# Memorandum

**Date:** July 19, 2024

**Re:** Re-submittal of Site Plan, 9610 and 9630 Universe Boulevard NW (PR-2020-004024/SI-2024-00648)

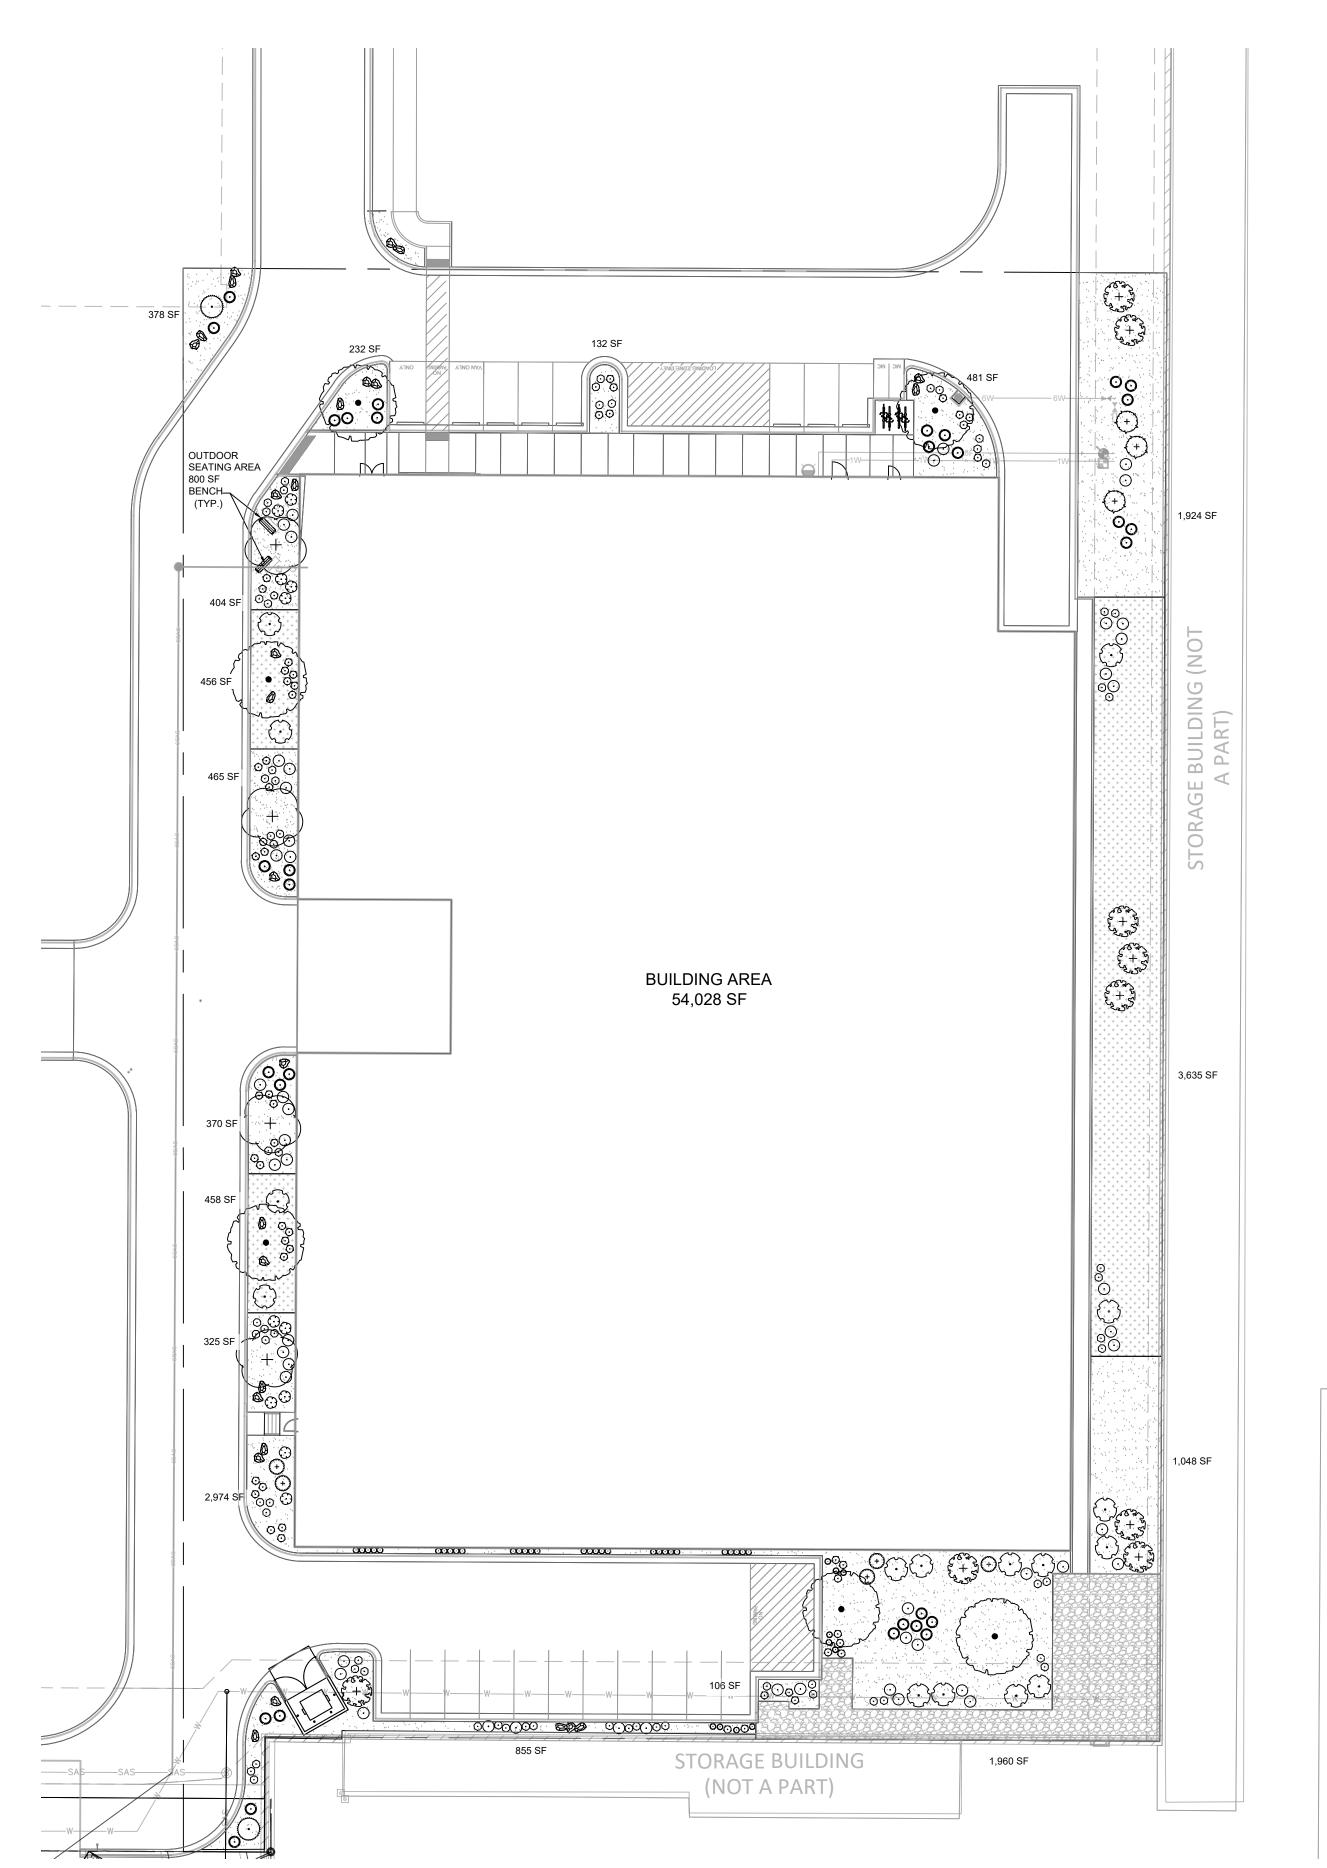
*Page 3: Updated 7/1/2024: It appears to be no drainage on the site, please confirm.*

*The project and application numbers must be added to the Site Plan and any associated IL.*

*Page 6: Please add the following note: "Rolled doors visible in the faux windows must match the color of the building façade, i.e., gray, and is not highly visible when lit."*

**Applicant Response:** Dave Aube, P.E., Thompson Engineering explained there is no need for a pond on the site. Stormwater runoff is diverted to the regional pond located southeast of the site. Rene Brissett from Hydrology confirmed that improvements to the regional pond are sufficient to support drainage from the site.

**Applicant Response:** Agreed. The project numbers and application numbers are included on re-submitted plans.

**Applicant Response:** The Applicant proposes that the note be slightly modified to allow adjustments to the color provided they are muted and are within the color palette specified in the VPO-2. The Applicant proposes the following note:

"Rolled doors visible in the faux windows shall be muted colors as shown on the building elevations."

LS 101

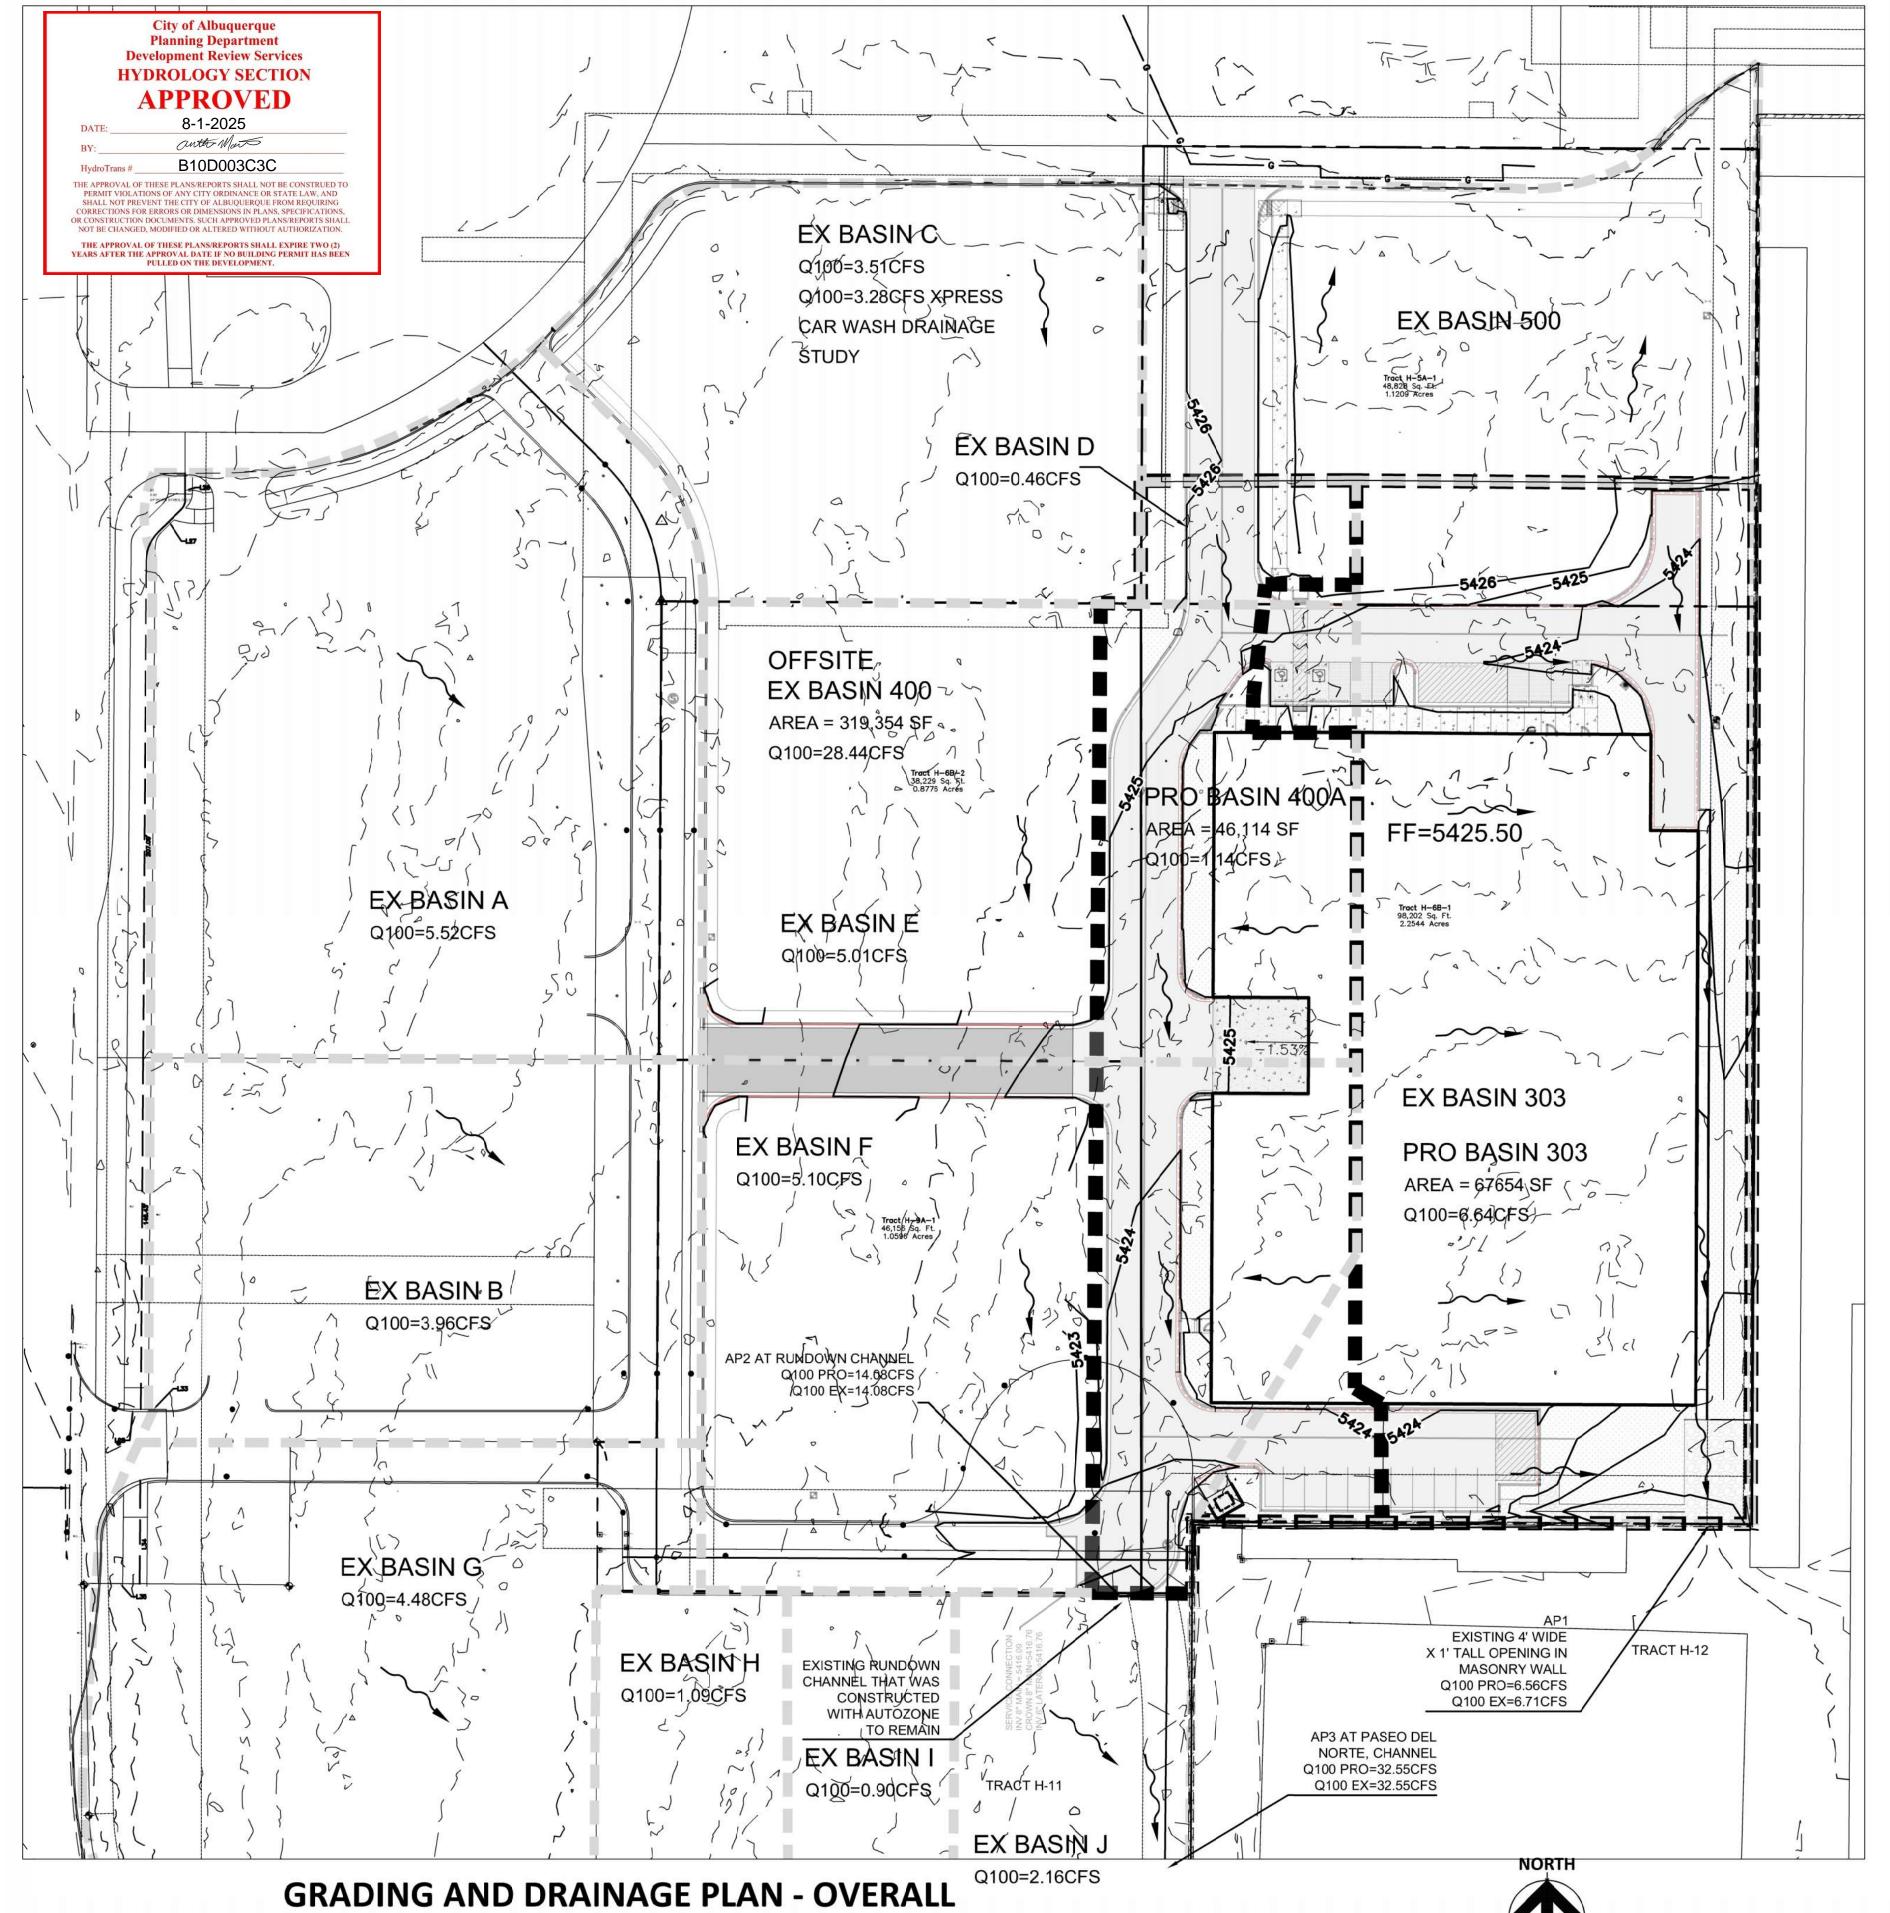
*Pages 6-7: An outdoor seating area is required for a primary building more than 30,000 s.f. per IDO Section 5-11(E)(3)(a).*

**Applicant Response:** The revised Landscape Plan includes 800 square feet of outdoor seating space at the northwest corner of the site, which contains two benches and shade from trees.

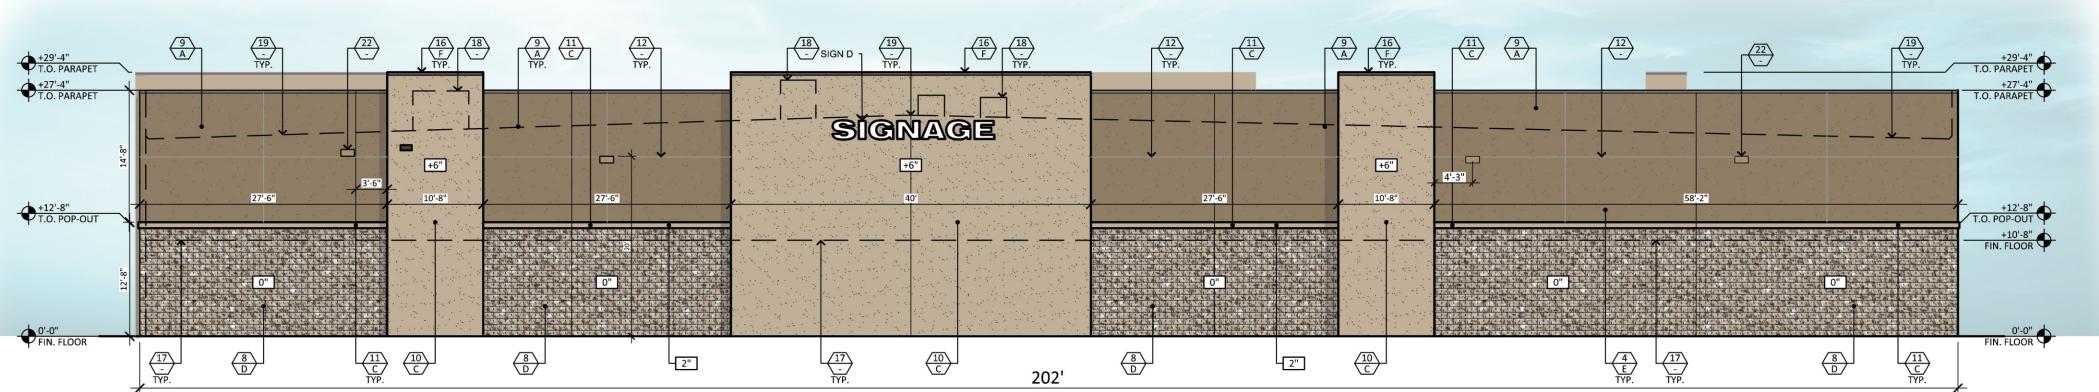
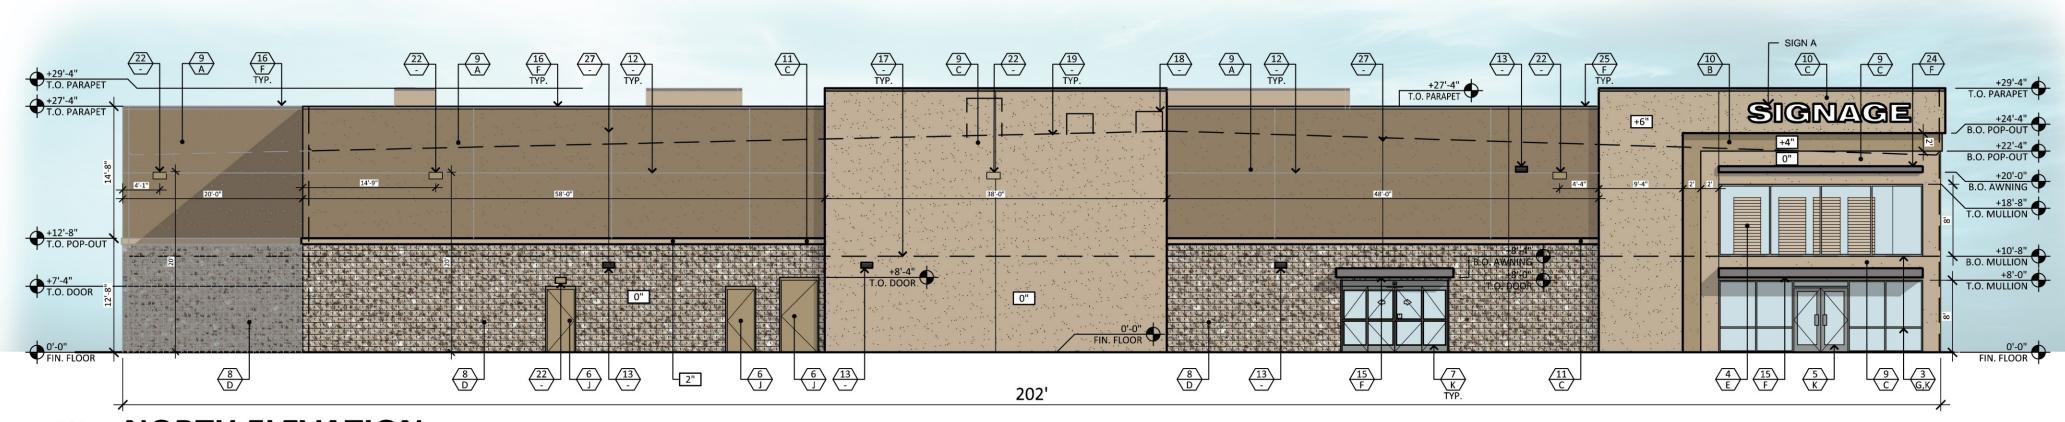
*Page 6: (2)(a)(2) – The façade incorporates two features: windows on upper floors and - ?? Primary pedestrian entrance.*

**Applicant Response:** The site does not have a street-facing façade, and therefore is not required to meet the standards in *IDO Section 5-11(E)(2)*. The south and western façade may be visible from Universe Boulevard and Paseo del Norte, but the building is located behind existing development which obscures the building. The proposed façade includes articulation, color variation, and windows on the upper floor contributing to an attractive building design.
